From: Clare Sutton (MHA) [REDACTED]
Sent: 20 September 2018 12:34
To: Stuart Corbey
Cc: Mark Coates
Subject: Ellis Close - parking ref AB/39/18/PL

Thank you for confirmation that this application is going to committee in October. I have read your report and picked up a couple of errors regarding the parking and since this is a contentious issue with the neighbours I think it would be worth correcting them:

Site Plan 1:200

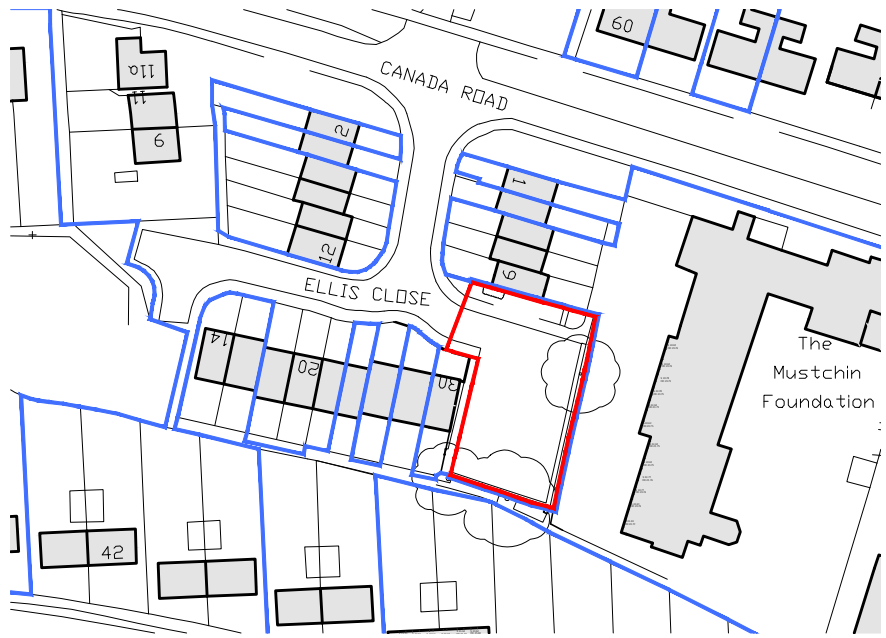
Firstly, the 6 space we are providing are not all allocated to the new houses. As shown on the schedule of accommodation on the site plan there will be one allocated space to each new house and 3 spaces re-provided as general parking.
